FAO: Planning Department,  
Welwyn Hatfield Borough Council

Ref: 6/2018/0136/LB  
Date: 22/10/2019

## HISTORIC BUILDINGS AND CONSERVATION ADVICE

**RE: *Oshwal Centre, Coopers Lane, Northaw, Potters Bar, EN6 4DG***

**DRAWING TITLE**  
WINDOWS 32-33A-33B

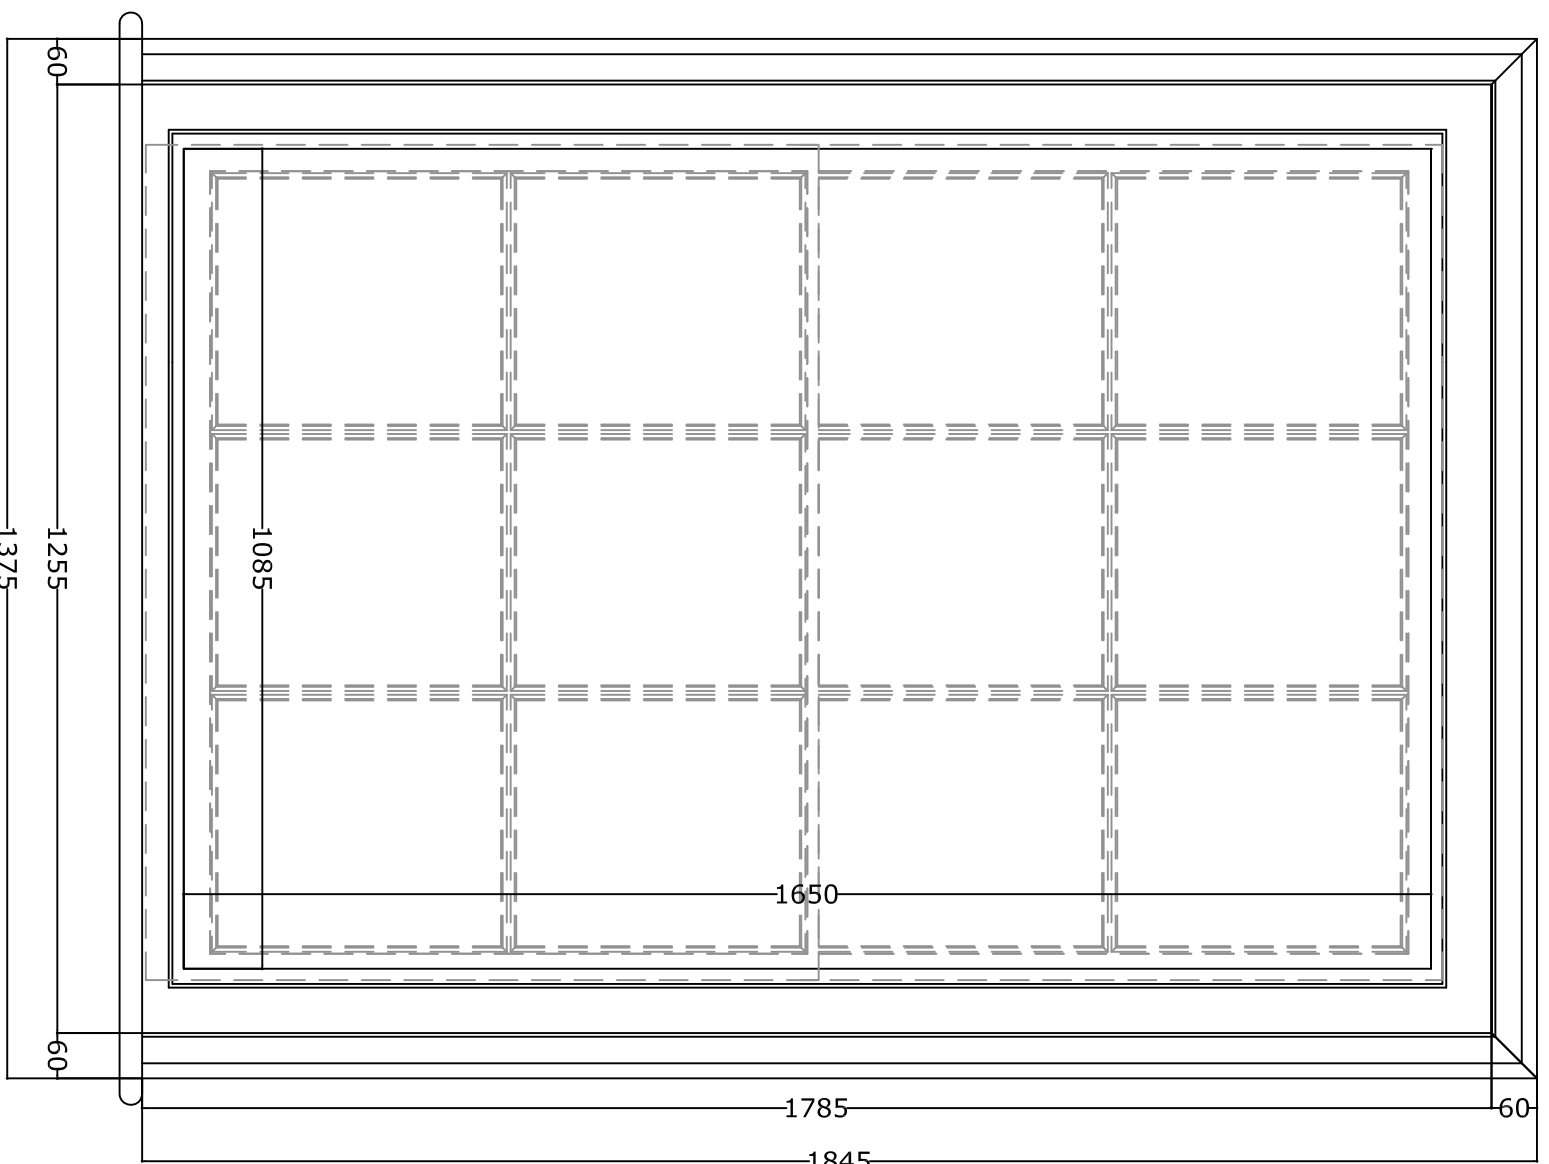
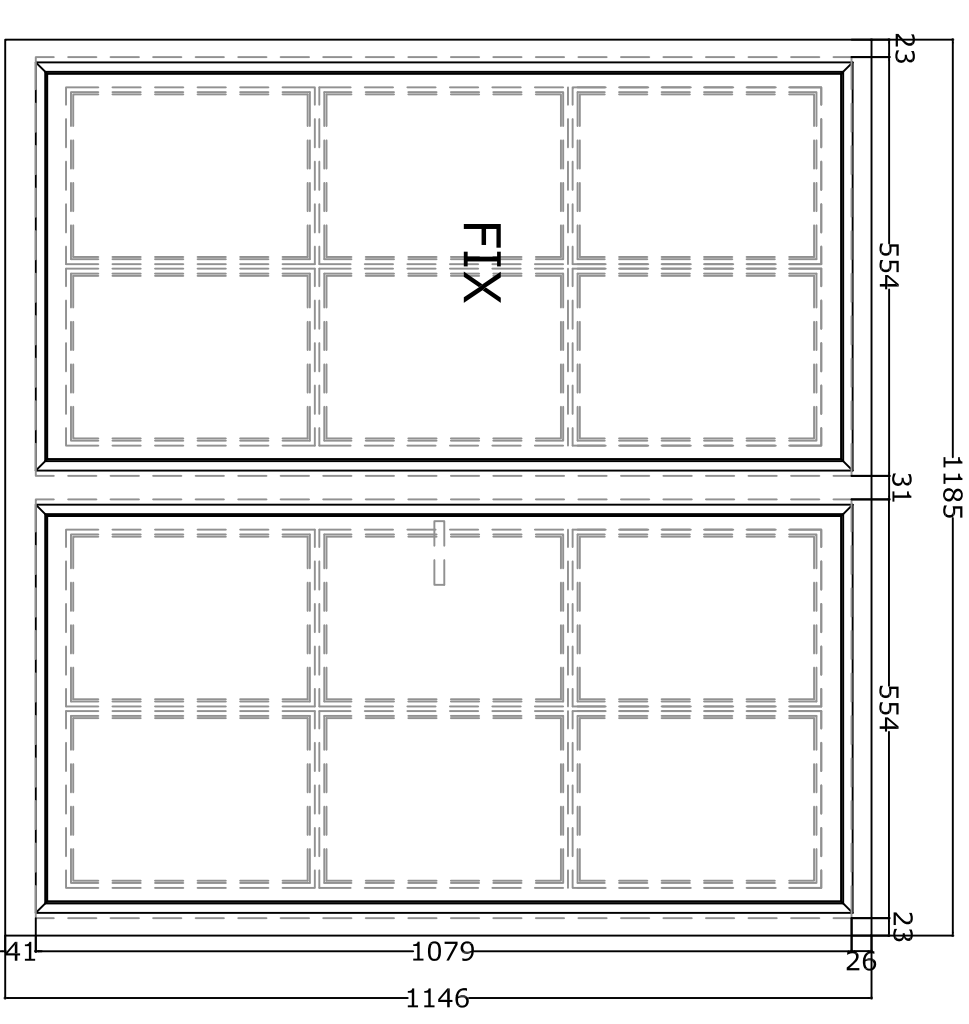
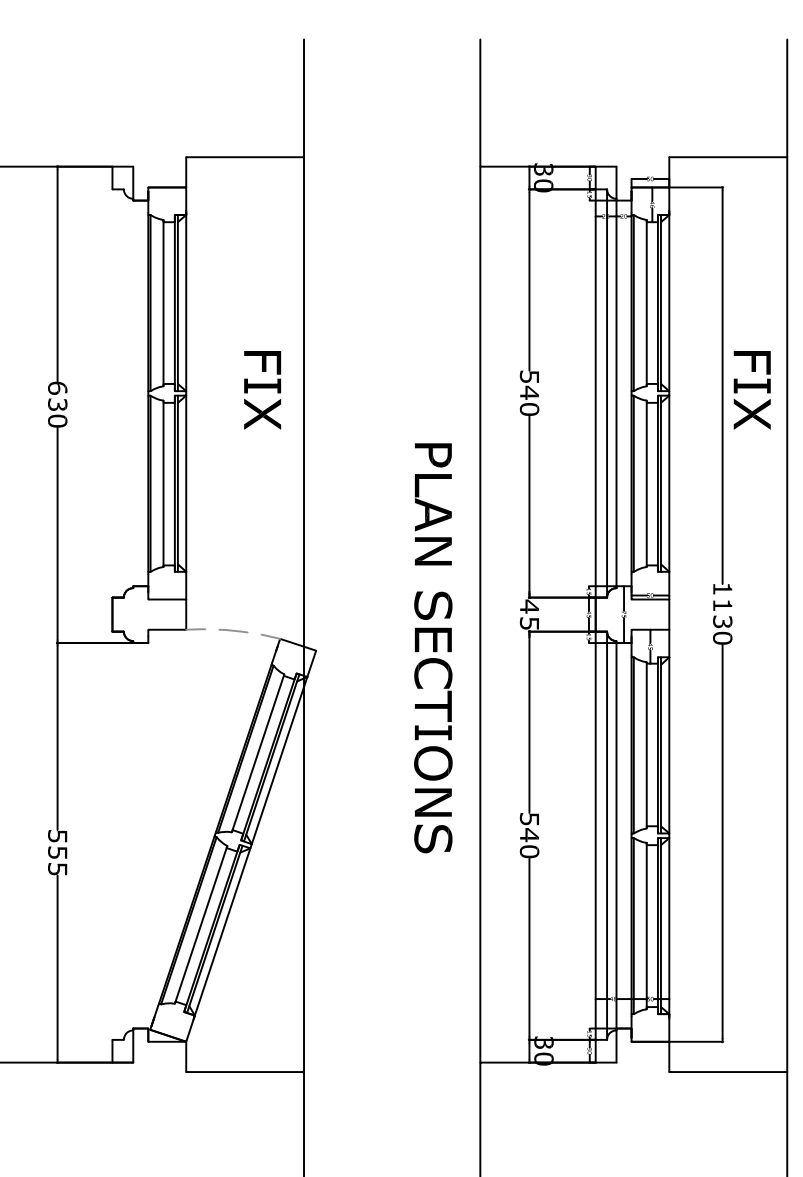
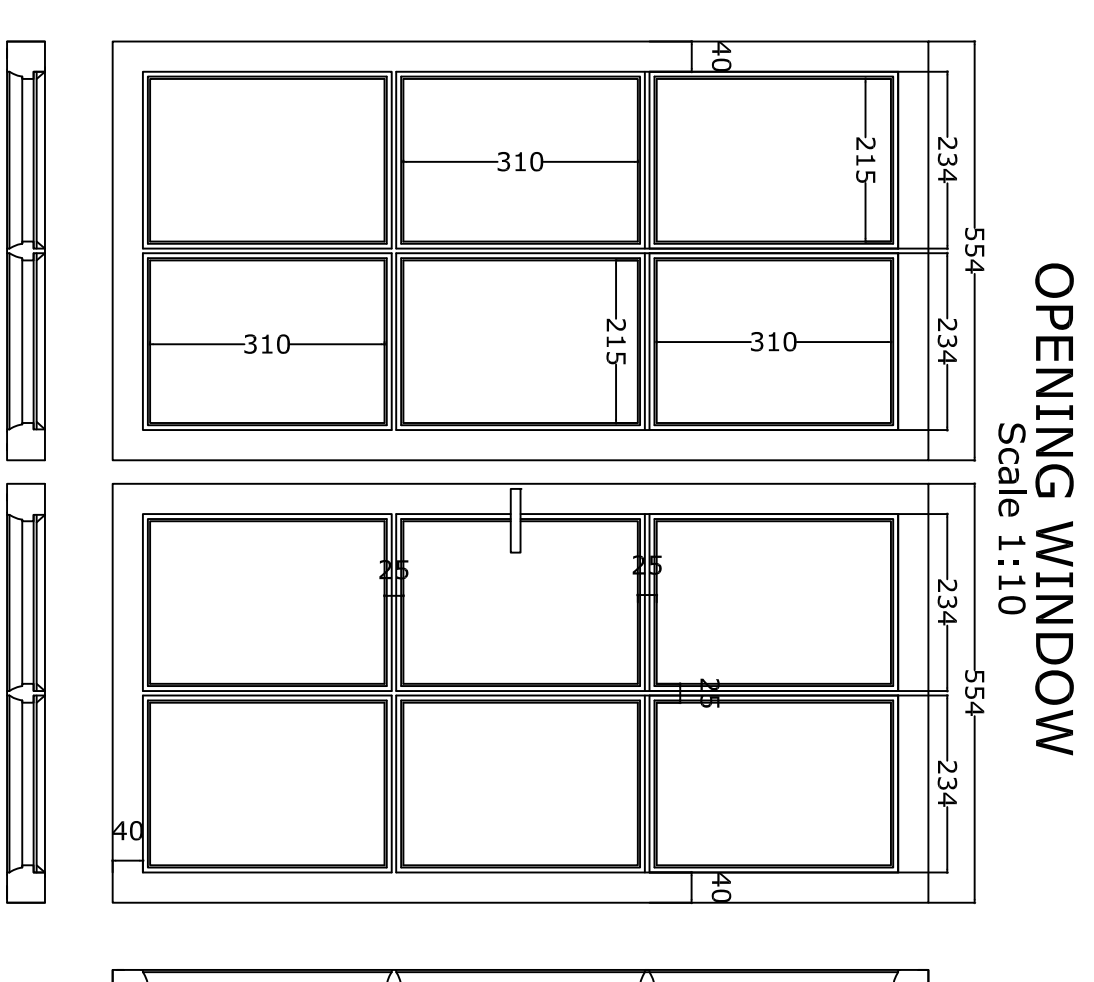
Window nos. 4, 5, 6, 7, 8, 9, 27, 28, 29, 30, 31, 32, 49, 50, 51, 52, 60, 61, 62 (paragraph no. 2.12 of *Heritage Statement*) appear to relate to a later phase of building work dating to the late 19<sup>th</sup> century. They are still of interest as historic elements of the building and their difference to the windows above is important in denoting the historic evolution of the building. Whilst not part of the primary phase, they are still of historic interest. It is recommended that these windows are also repaired and

only replaced if beyond viable repair. The replacements should be on a like-for-like basis including single glazing. Double glazing will not be acceptable.

The replacement of the mid-late twentieth century windows (nos. .10, 11b, 11c, 33, 33b, 53, 54, 55 as per paragraph no. 2.14) raises no objection in principle but their replacements should be of a design more appropriate to the historic building, taking reference from the existing historic windows. Elevation and section details of the proposed windows is required to judge their impact on the listed building.
